Dolwende Quarry Project

Supplementary Response to Submissions Report

Upper Hunter Holdings Pty Ltd

17 October 2016

Figure 11: Conceptual rehabilitation plan

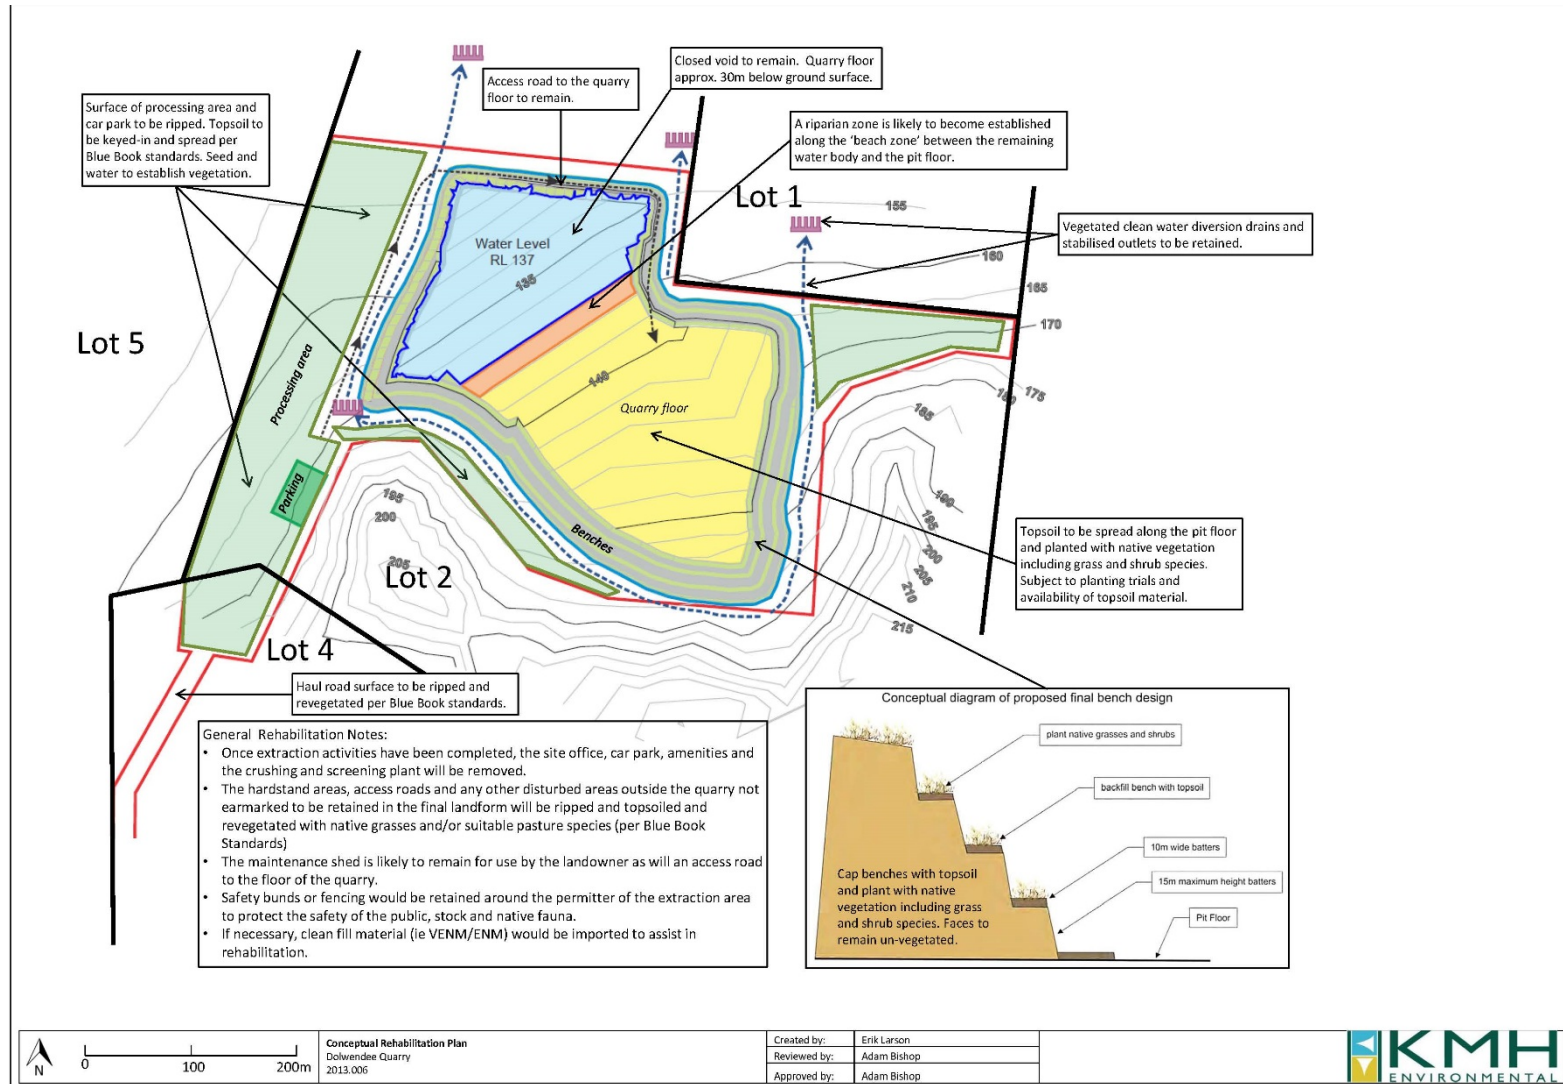
<ul style="list-style-type: none"> In addition, we require a conceptual plan of the final landform of the quarry and how it will be rehabilitated following closure. This is a standard requirement for many SSD quarries, which forms part of a development consent. We also consider this to be particularly necessary due to the use of the uncertain language used to describe the final landform as including a “closed void”. We do not consider this provides the Department, stakeholders, or the community with a clear understanding of whether an acceptable landform would be left in the landscape after extraction is complete. <p>(KMH, July 2016) and clear up any uncertainty, we can confirm that the final landform includes a closed void with a gently sloping quarry floor and benched quarry faces. A closed void is a pit that is not free draining from a drainage perspective, ie it does not have an outlet for stormwater to drain away to the surrounding landscape. This is because the pit would be excavated to approximately 30 m below the surrounding ground level.</p> <p>The key objective of the progressive and final (closure) rehabilitation strategy would be to establish a stable landform that minimises risks to safety and the environment. The rehabilitation objectives and methods would be detailed in a Rehabilitation and Closure Strategy to be prepared at a later stage as the quarry is nearer to closure, approximately during stage 3 of development.</p> <p>The quarry floor and benches would be rehabilitated progressively by suitable means to suppress dust, minimise erosion and minimise potential for weed establishment. The methods employed would be dependent on various factors, not least of which will be the availability of overburden and topsoil for preparation of a suitable growth substrate for revegetation. Native vegetation would be employed where appropriate and subject to the success of planting trials. An access ramp would be maintained to the quarry floor.</p> <p>The proposed final quarry batter faces would remain at a slope of approximately 0.5 horizontal : 1 vertical. The height of these final faces would require review as the quarry develops, in conjunction with the Mines Safety Inspectorate. It is unlikely that the faces will have any vegetation on them as they will not be visible to neighbours, do not pose a significant erosion hazard and the roots of plants can over time destabilise the stratum and make the faces unsafe.</p> <p>Progressive rehabilitation of disturbed areas would be undertaken outside the active extraction area in locations that are disturbed temporarily during construction but not required for operations. This would include, for example, any temporary storage/laydown areas, large or steep road batters, earth bunds and drains conveying concentrated stormwater flows.</p>

<p>As part of a closure plan, the processing and administration areas external to the quarry would be revegetation and returned to a stable condition upon the removal of all equipment and materials. Techniques for rehabilitation would typically include:</p> <ul style="list-style-type: none"> • Ripping surfaces of the processing area and any disturbed lands to be rehabilitated to a depth of 250 mm to key in topsoil; • Spreading topsoil stripped from the site prior to the quarry operations to form a minimum 100mm deep layer; • Seeding with the preferred plant mix; • Watering, fertilising and maintaining vegetation as necessary to ensure successful establishment; and • Maintaining sediment and erosion controls until the site is stable. <p>Clean water diversion drains would be maintained around the high side of the quarry to help maintain the stability of the faces and minimise water capture within the closed void. Safety bunds or fencing would be retained around the perimeter of the extraction area to protect the safety of the public, stock and native fauna.</p> <p>Once extraction and product haulage has ceased the haul road would be rehabilitated, potentially (should the landowner agree) leaving a single lane farm track for access. Rehabilitation of the haul road would include ripping the road surface, spreading topsoil and revegetating.</p> <p>Should it be considered necessary or beneficial to attainment of the rehabilitation objectives, the operators may seek to import clean fill material (ie VENM/ENM) to assist in rehabilitation. For example, to provide supplementary growth materials (topsoil and subsoil) for rehabilitation of the quarry floor if there is a shortage of materials available onsite.</p>
